**SUBMISSION TO THE DEPARTMENT OF PLANNING AND INFRASTRUCTURE ON THE PROPOSED
NORTH WEST RAIL LINK (NWRL)**

Name: BEVAN DAMM

Application Number: SSI-5100

Figure 6.11 Cheltenham Services Facility light vehicle access and egress

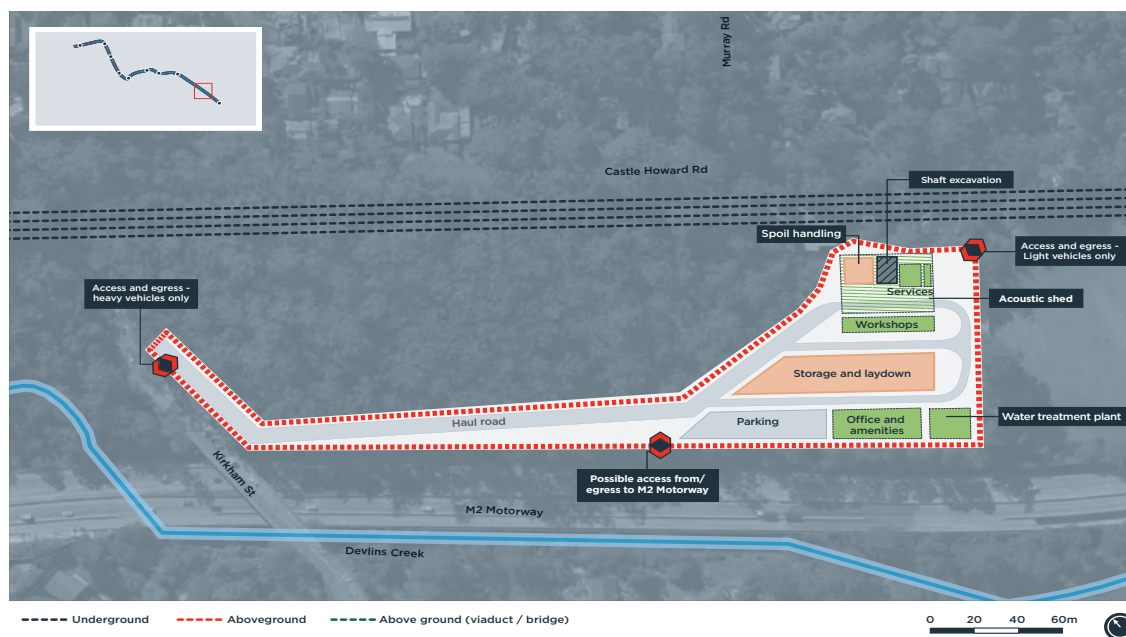
1. The option to construct a new two lane paved road through the Castle Howard Conservation Reserve to Kirkham Street (or Castle Howard Road) near the bridge over the M2 to allow trucks to remove spoil during construction and light vehicle access during operation of the facility will permanently destroy valuable Blackbutt Gully forest.

5. Should the roadway be built, the local streets (Kirkham Street, Castle Howard Road, Murray Farm Road and the bridge over the M2) are narrow, winding and congested and would not be suitable for trucks and, in the event of an emergency, large numbers of emergency vehicles.

6. There are no traffic lights at the corner of Kirkham Street and Beecroft Road. This is a dangerous intersection for traffic and pedestrians and would not be suitable for trucks and emergency vehicles.

I therefore ask that you adopt the alternative option of access to the site for construction and emergency vehicles be via new on and off ramps from the M2 motorway. The current widening and reinstatement of the breakdown lane should allow this access. It is the only practical way to move trucks in and out of the site. In the event of an emergency, many emergency vehicles would need quick access to the site from areas outside Beecroft and Cheltenham as it only has one fire engine.
